Engineers Comments Regarding Surface Water Drainage

Application No: BN/151/20/PL

Site Address: Land at rear of Poachers Eastergate Lane Eastergate PO20 3SJ

Description of Works: Erection of 1 No. 4 bedroom detached dwelling with detached carport (resubmission following BN/46/20/PL). This site is in CIL Zone 3 & is CIL Liable as new dwelling & is a Departure from the Development Plan.

GENERAL DRAINAGE SPECIFICATION

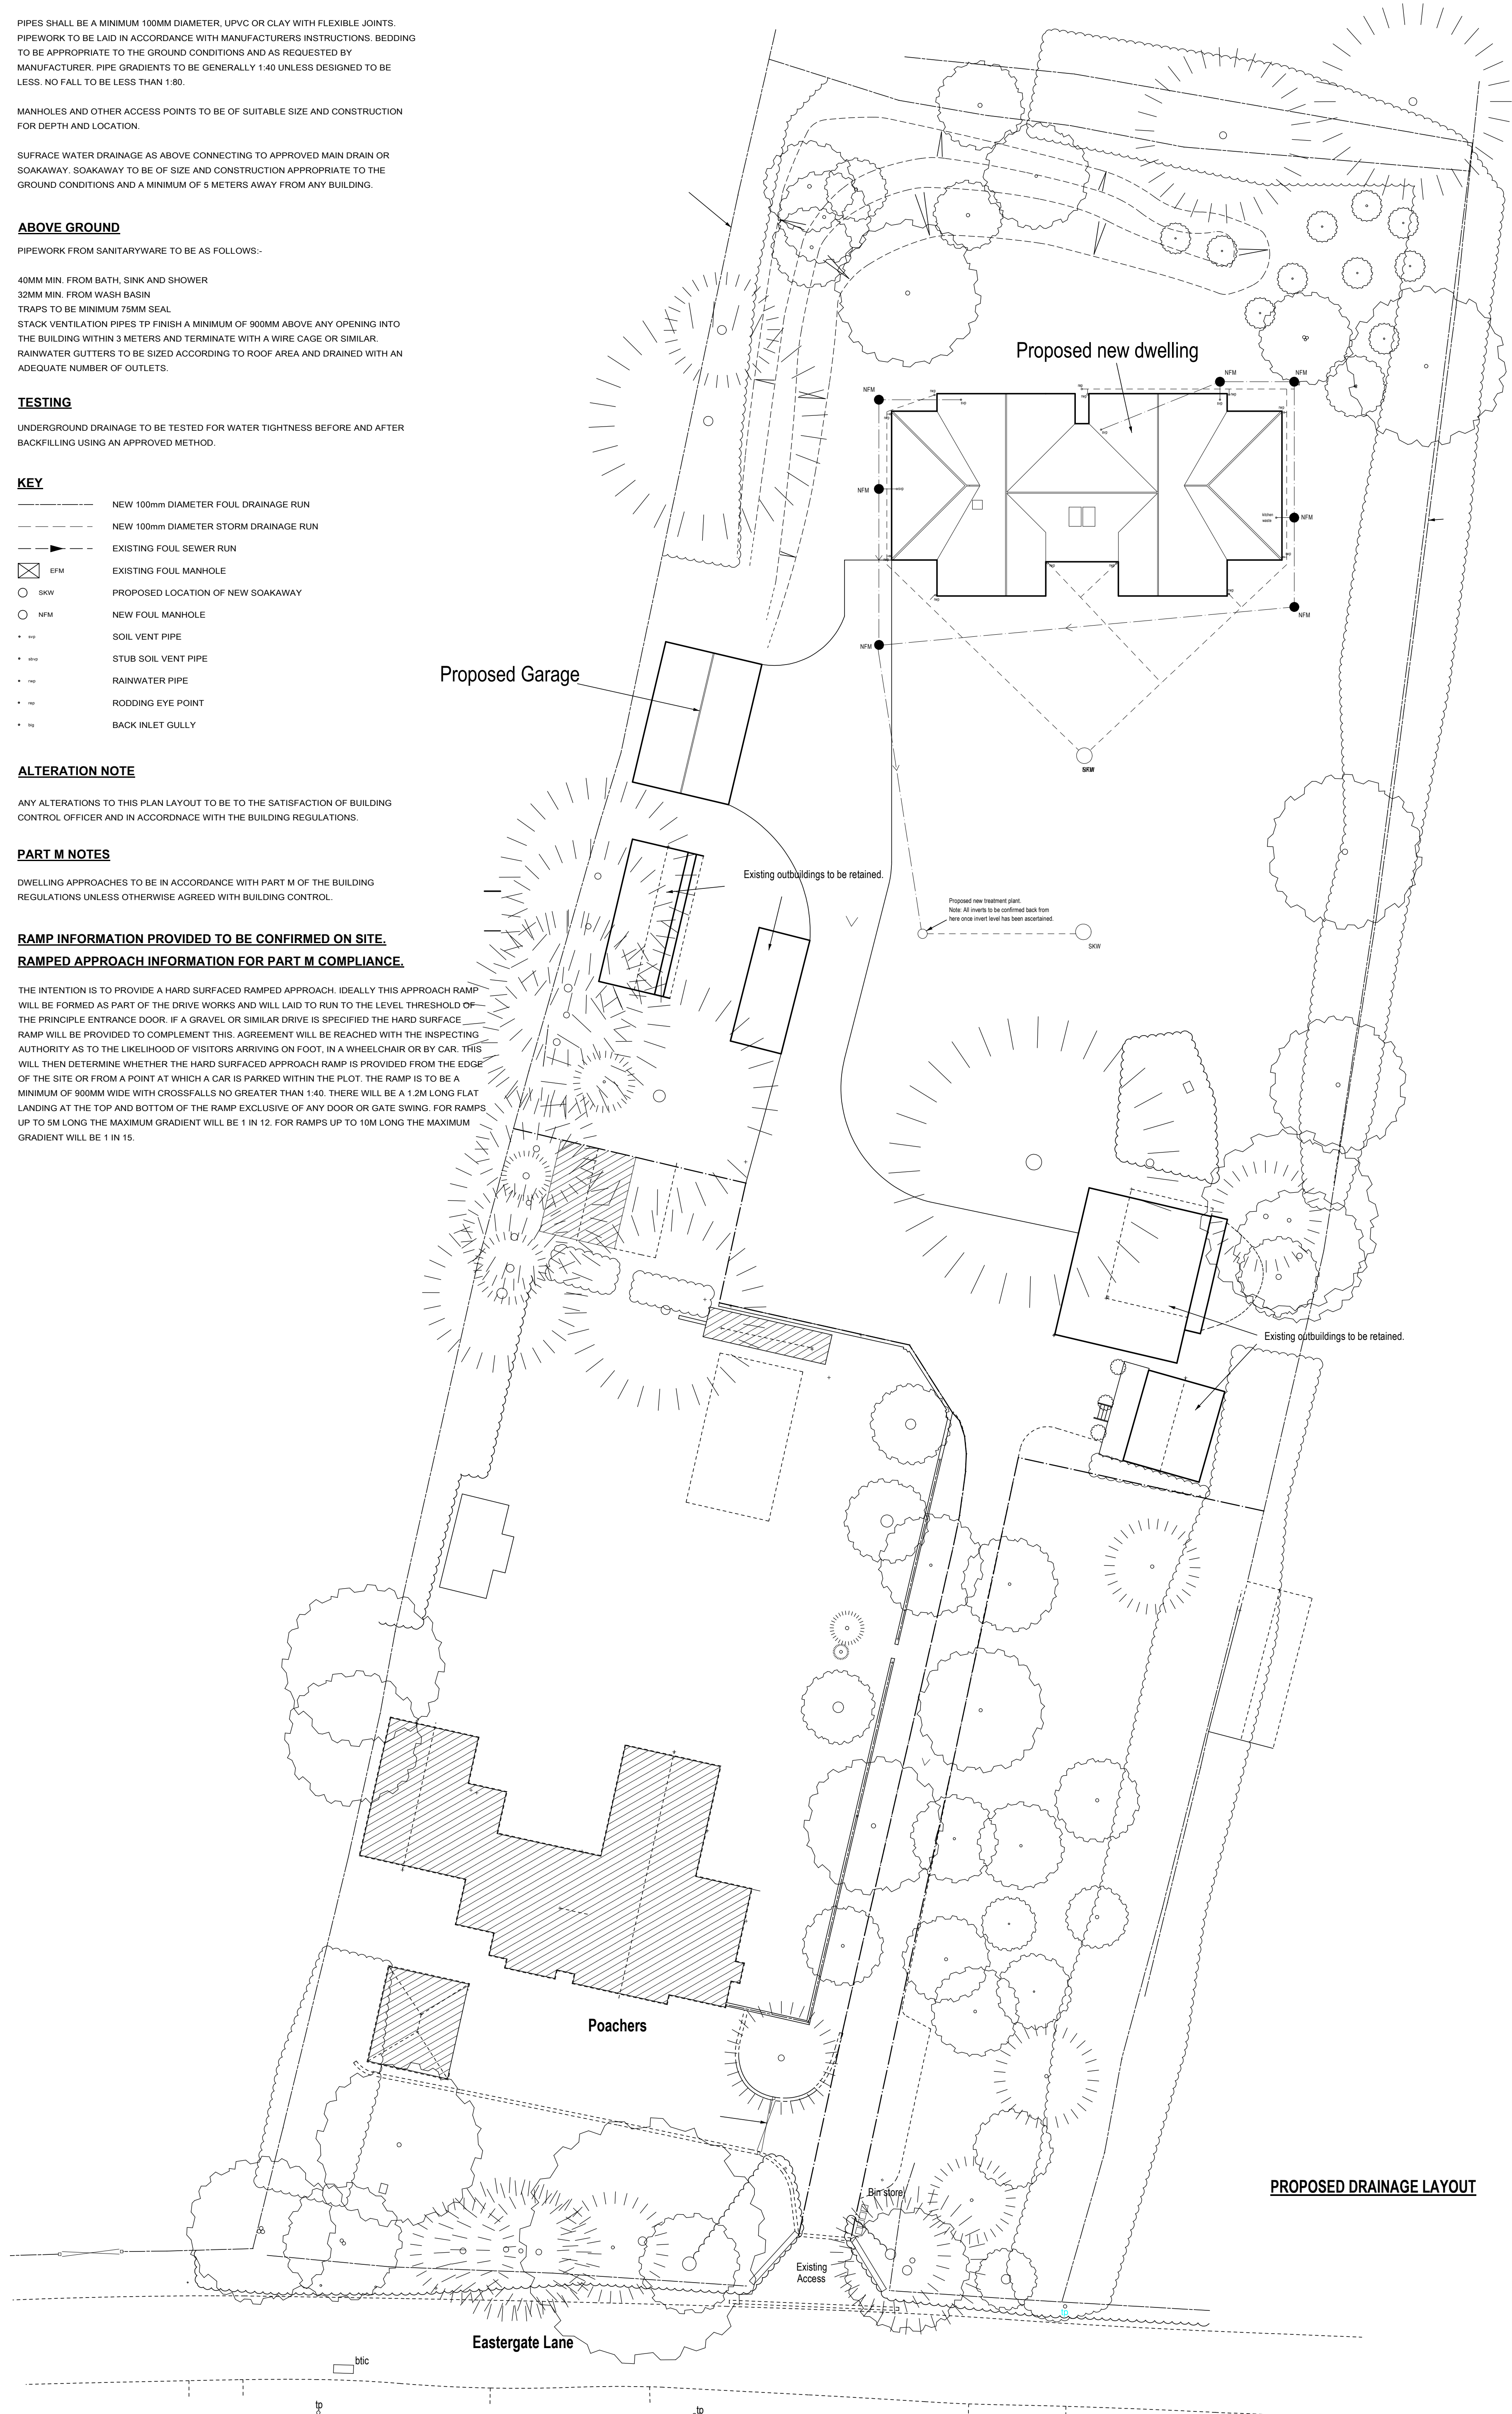
The application is within the Lidsey Treatment Catchment, therefore surface water drainage design should be carefully considered. Infiltration must be fully investigated. A General Drainage Specifications/Layout has been

provided, however it appears that no infiltration testing or groundwater monitoring has been undertaken to inform the detailed design. No detailed design, calculations or construction details have been supplied at this stage.

“Development shall not commence, other than works of site survey and investigation, until full details of the proposed surface water drainage scheme have been submitted to and approved in writing by the Local Planning Authority. The design should follow the hierarchy of preference for different types of surface water drainage disposal systems as set out in Approved Document H of the Building Regulations, and the recommendations of the SuDS Manual produced by CIRIA. Winter groundwater monitoring to establish highest annual ground water levels and winter Percolation testing to BRE 365, or similar approved, will be required to support the design of any Infiltration drainage. No building / No part of the extended building shall be occupied until the complete surface water drainage system serving the property has been implemented in accordance with the agreed details and the details so agreed shall be maintained in good working order in perpetuity.”

“Infiltration rates for soakage structures are to be based on percolation tests undertaken in the winter period and at the location and depth of the proposed structures. The percolation tests must be carried out in accordance with BRE365, CIRIA R156 or a similar approved method and cater for the 1 in 10 year storm between the invert of the entry pipe to the soakaway, and the base of the structure. It must also have provision to ensure that there is capacity in the system to contain below ground level the 1 in 100 year event plus 40% on stored volumes, as an allowance for climate change. Adequate freeboard must be provided between the base of the soakaway structure and the highest recorded annual groundwater level identified in that location. Any SuDS or soakaway design must include adequate groundwater monitoring data to determine the highest winter groundwater table in support of the design. The applicant is advised to discuss the extent of groundwater monitoring with the Council's Engineers.
